Objection to Planning Application BN/18/20

I note with some concern this application made by, or on behalf of, Barratt-David Wilson Homes for variation of Condition 15 applying to permission EG/29/13 relating to 40 residential dwellings at the former Brooks Nursery site with access from Barnham Road.

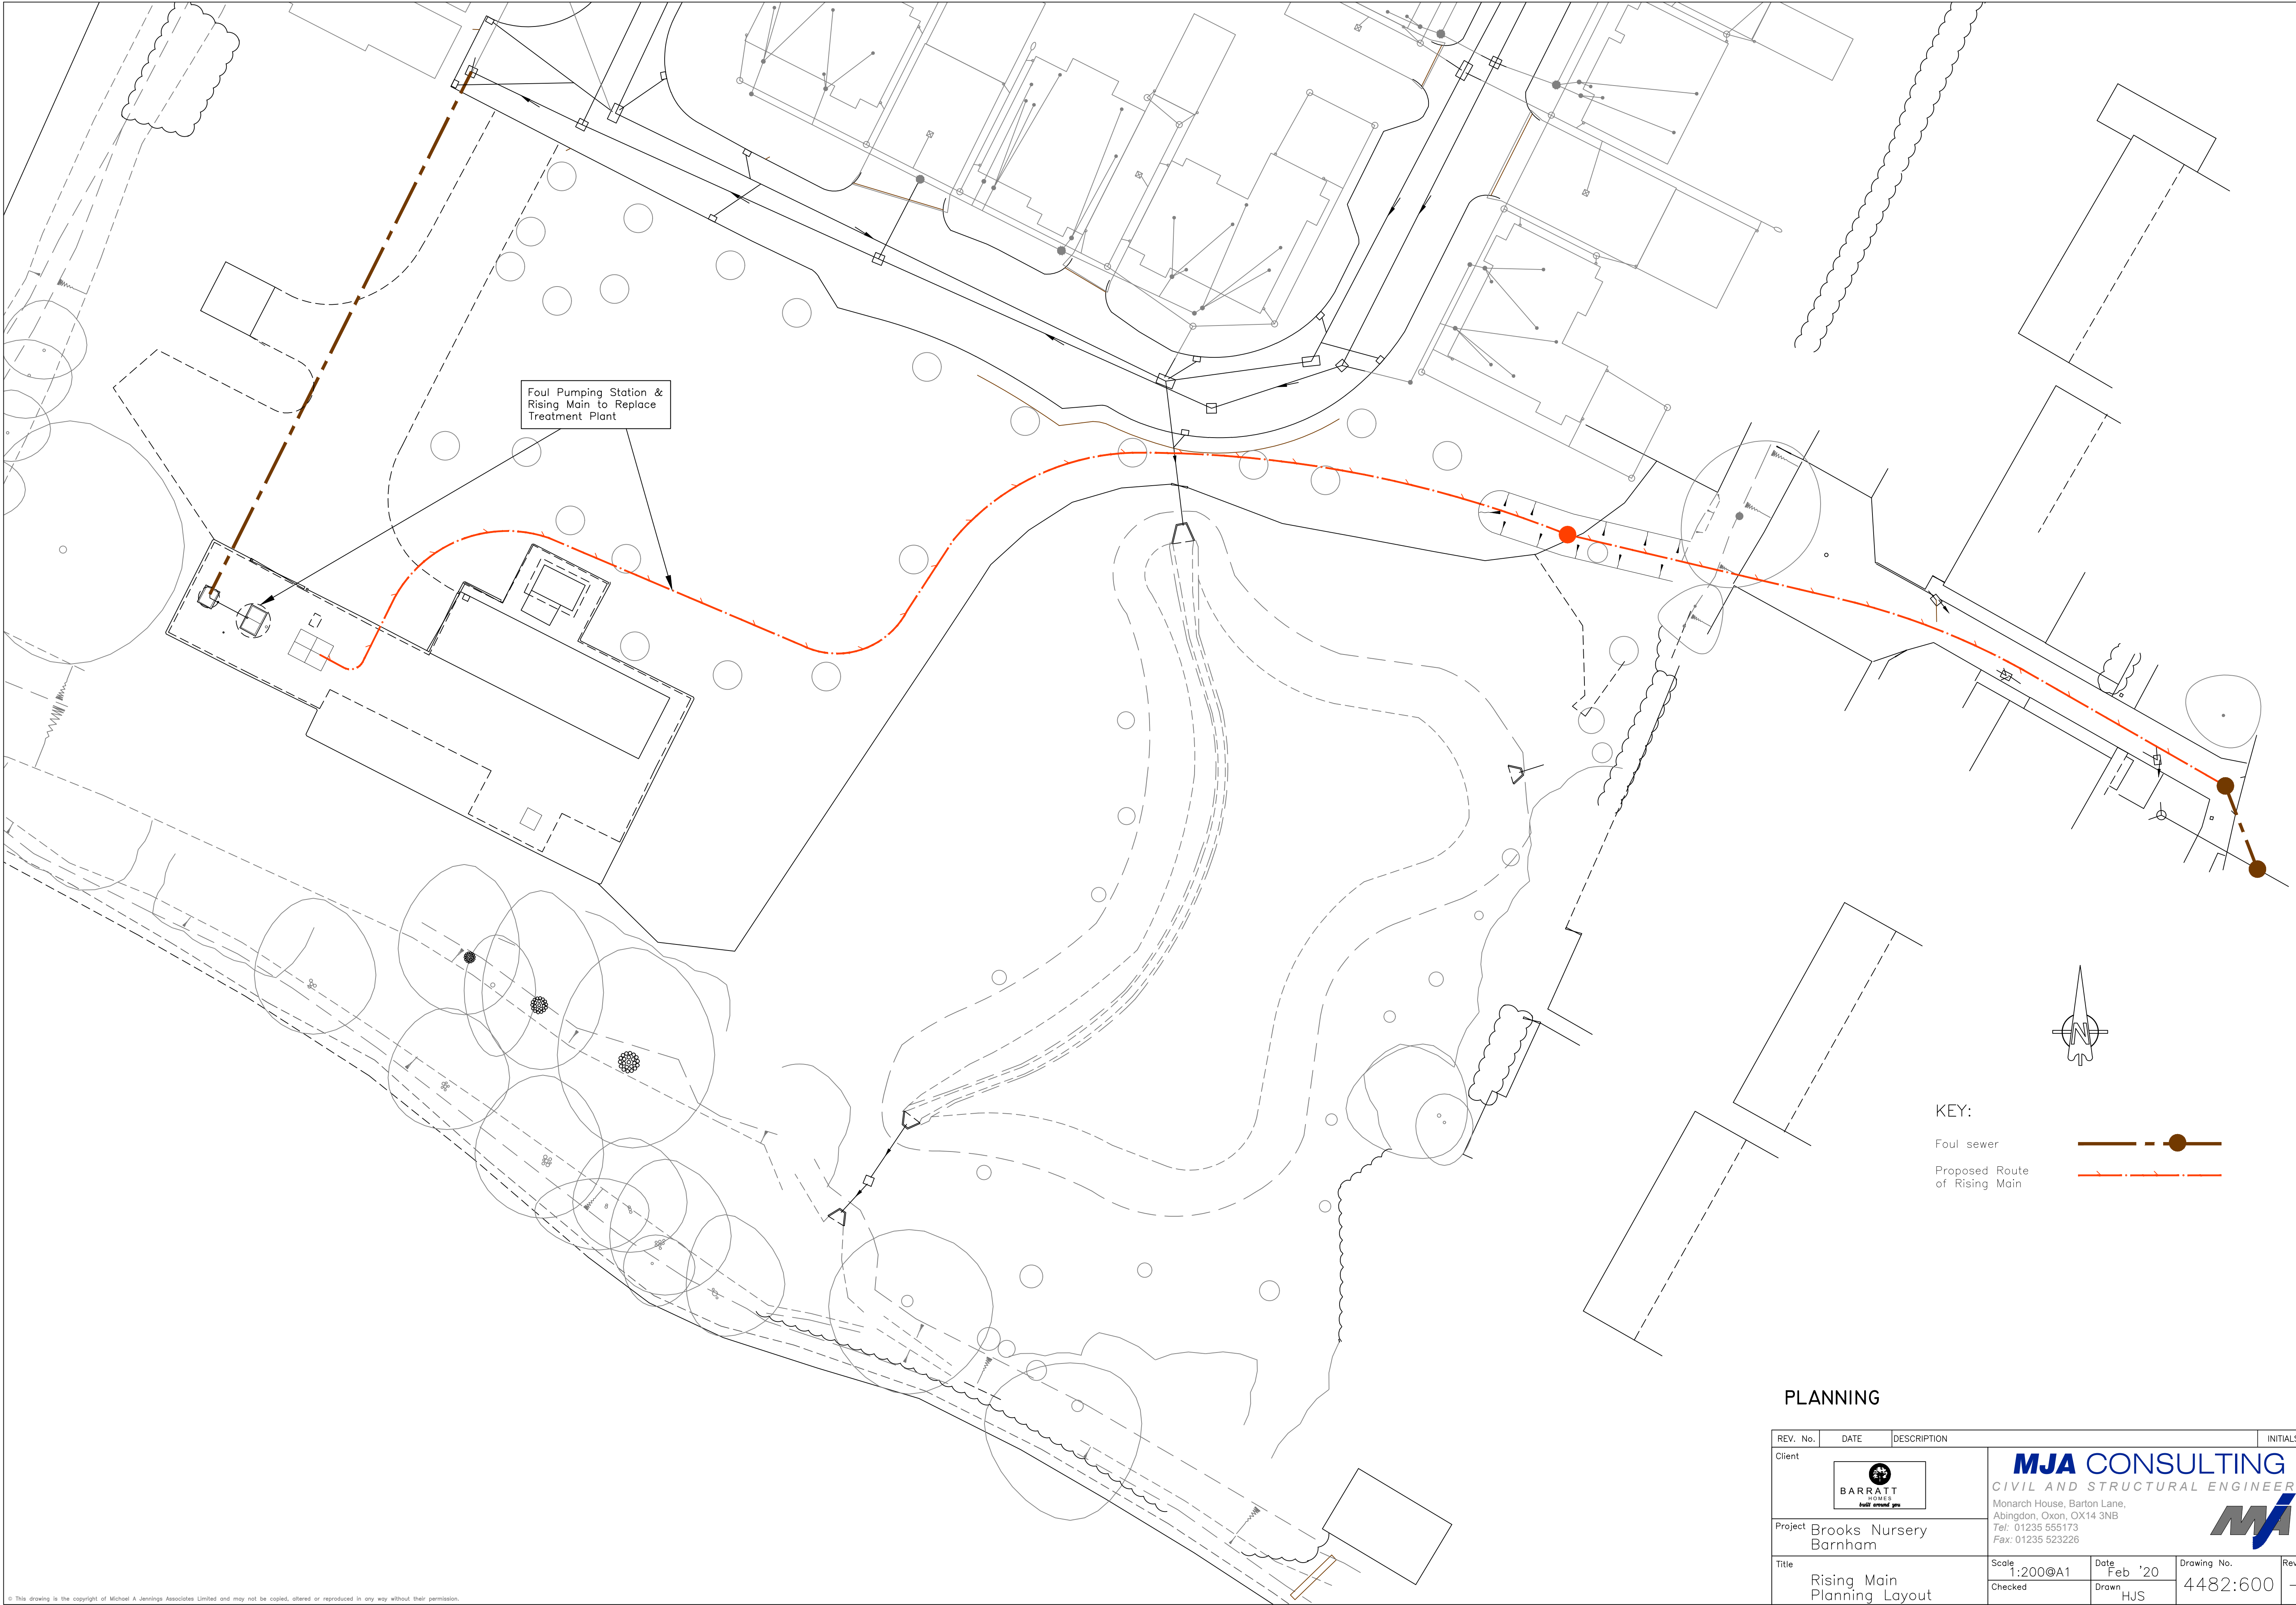
1. The intention appears to be to pump waste water through an 8" (200mm) main into an existing 6" (150mm) main. The cross sectional area (CSA) of a 150mm pipe is 9/16 (about 56%) of the CSA of a 200mm pipe. As a result the level of effluent in the smaller pipe would be proportionately higher than that in the larger pipe. As an example: without allowing for the effect of the enhanced flow rate of the pumped effluent compared with gravity induced flow, if the 200mm main were 1/3 full where it met the existing 150mm main then the existing main would be filled to over 50%. This, of course, is without the additional effluent from the existing properties on Elm Grove South. If the pumped 200mm section were half full the 150mm main would become over 80% full, which is obviously unacceptable. At times of high inflow rates this could lead to unacceptable load on the system leading to backing up of the system into existing properties.

3. At the point where the diameter reduces from 200mm to 150mm there will be inevitable acceleration of the effluent flow which could result in unacceptable turbulence and resultant erosion and eventual failure of the pipes.
